**KIRKLEES METROPOLITAN COUNCIL
INVESTMENT & REGENERATION SERVICE**

Reference No: 2019/62/90715/E

Site Address: Rose Cottage, Church Lane, Thornhill, Dewsbury,
WF12 0JZ

Description: Erection of conservatory and replacement chimney
pot to roof (within a Conservation Area)

Proposed Plan View (With Boundary)

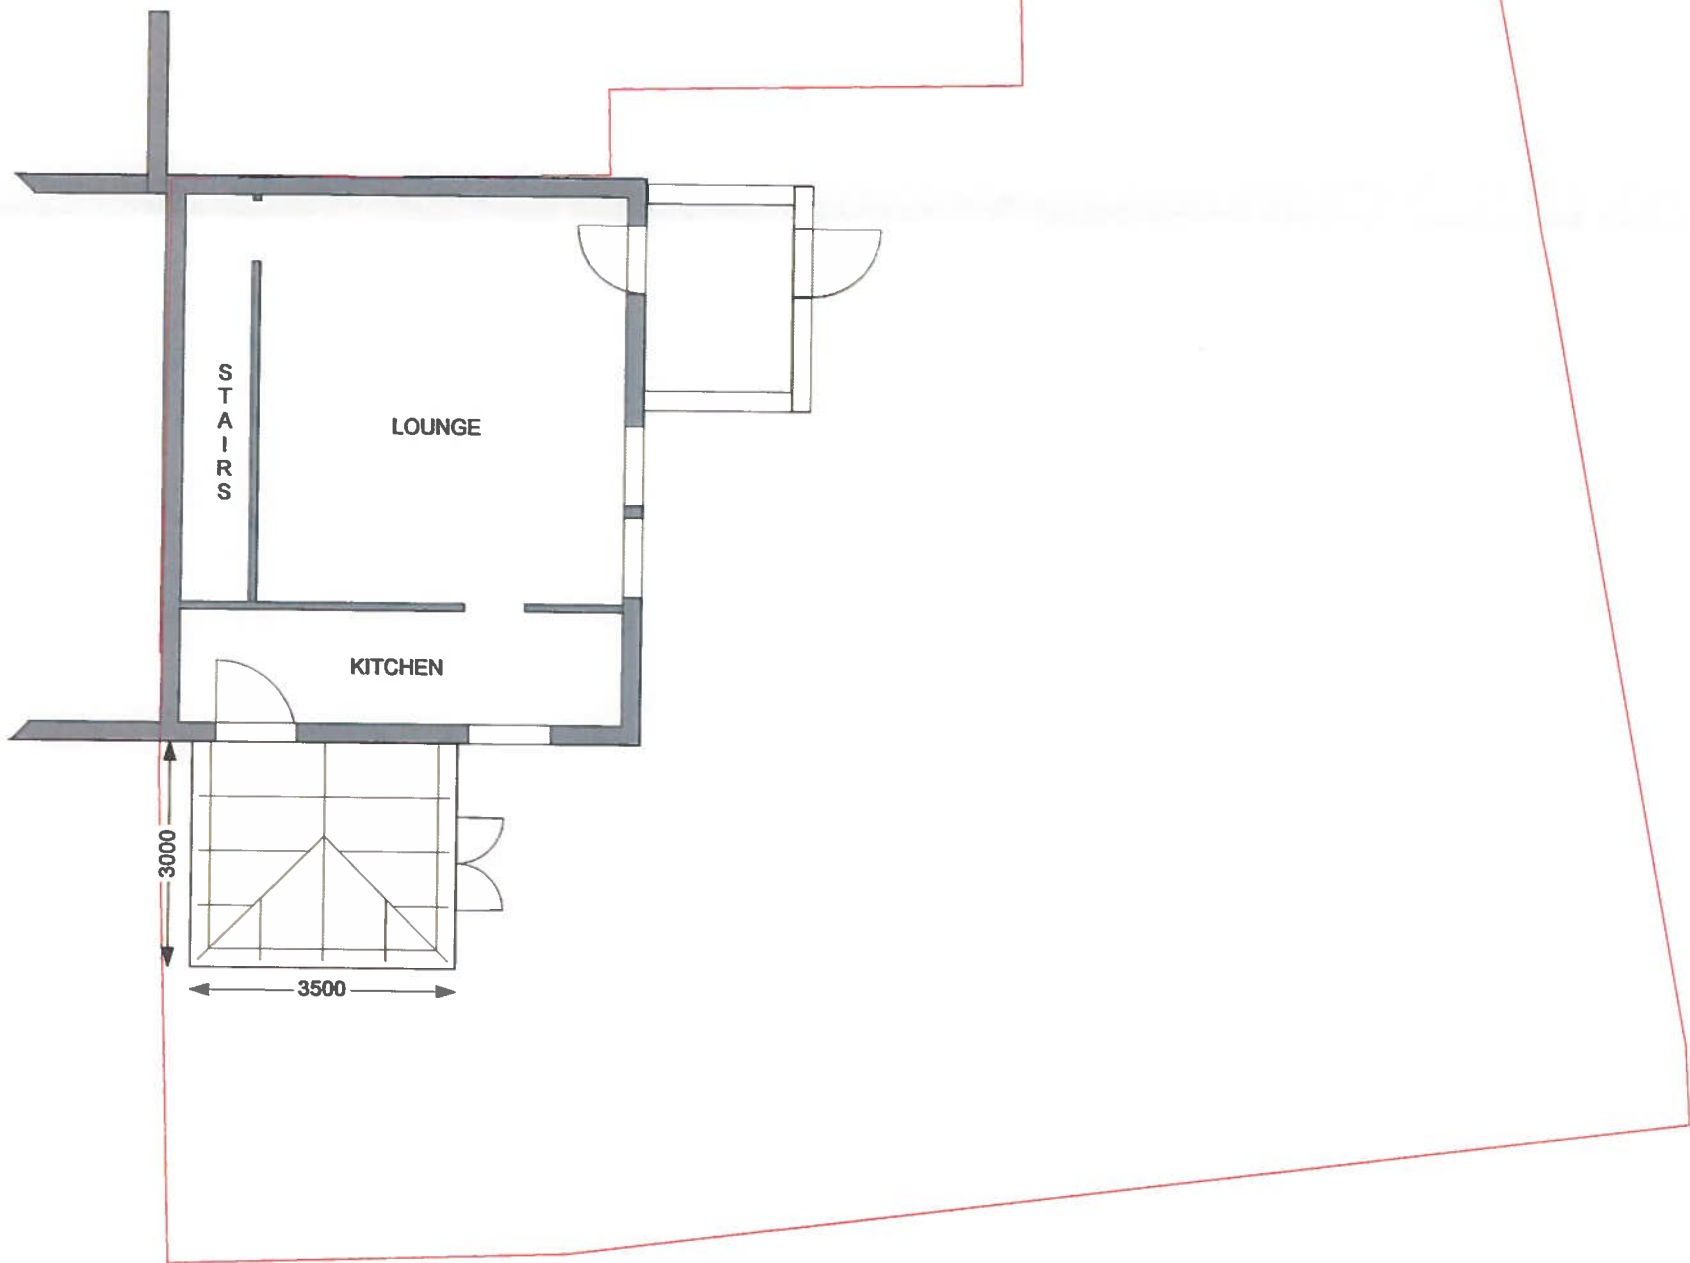
The maximum projection of the rear extension will be 3m from the eastern facing elevation at the host property. The overall projection of the extension has been considered acceptable from a visual perspective.

Roseville is the adjoining neighbour to the south of the application site. It has been considered that the proposed extension would have some impact on these neighbours' amenity. More specifically, in regards to overbearing, the submitted plans show the extension to be slightly inset from these neighbours and to have a maximum projection of 3m. For these reasons, it has been considered that any impacts on overbearing can be supported.

In regards to overlooking, the submitted plans show bi-fold doors to be inserted into the north facing elevation of the extension. At the time in which the site visit was undertaken it was evident that these neighbours did not have any existing openings directly opposite this elevation of the extension and therefore any harm on overlooking can be supported.

- Plans show larger area than what there is

Response: The onus is on the applicant and agent to submitted correctly scaled plans therefore the application has been assessed in its submitted form.
